**ADVICE RESPONSE:** Kurri Kurri Lateral Pipeline Project - Submissions and Amendment Report advice - (SSI-22338205)

I refer to your correspondence dated 4 October 2022 inviting the Department of Regional NSW – Mining, Exploration & Geoscience (MEG) to provide comments on the Kurri Kurri Lateral Pipeline Project - Submissions and Amendment Report advice - (SSI-22338205) (the Project).

APPENDIX 3: DONALDSON MINE ALTERNATIVE ROUTE OPTION

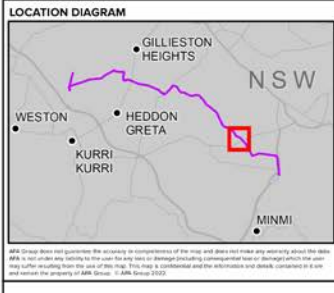
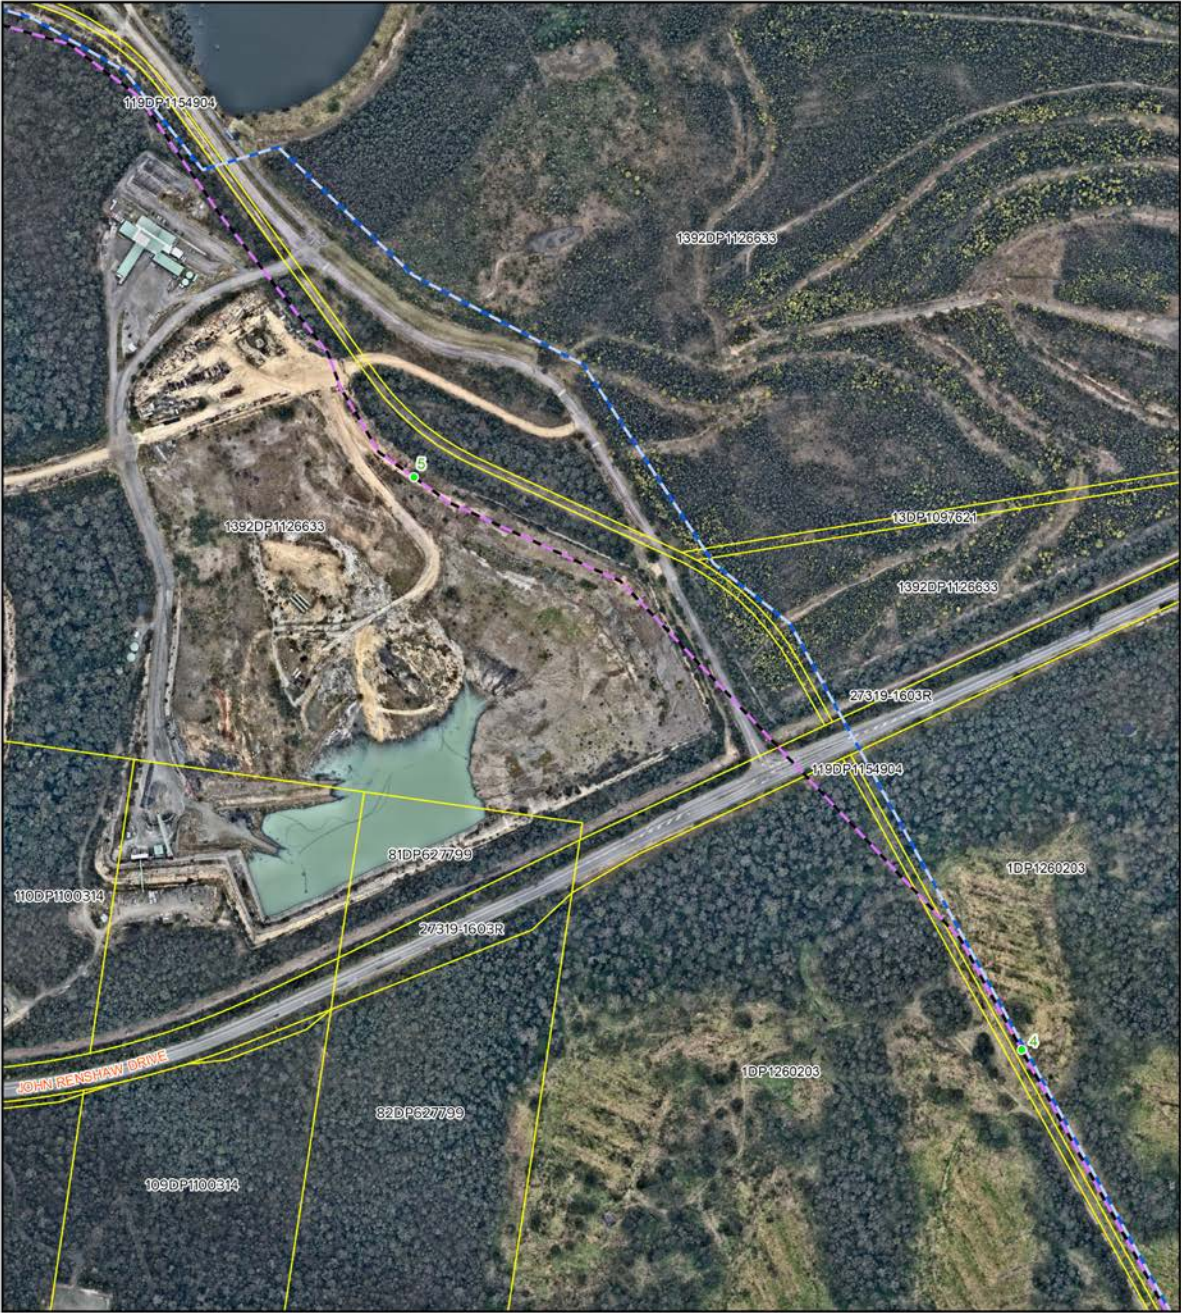
The Resources Regulator branch requests further information be provided to ensure that the position of the pipeline route doesn't restrict rehabilitation activities and/or final landform options associated with the Donaldson and Able mining operations. Specifically, highwall stabilisation measures that need to be implemented as part of the closure of the mining operations.

Regarding the pipeline location, MEG is satisfied that the pipeline easement can coexist with the existing mining leases with the proponent to ensure that private administrative/access arrangements between the involved parties are in place. This position is pending the resolution of any impacts on rehabilitation options.
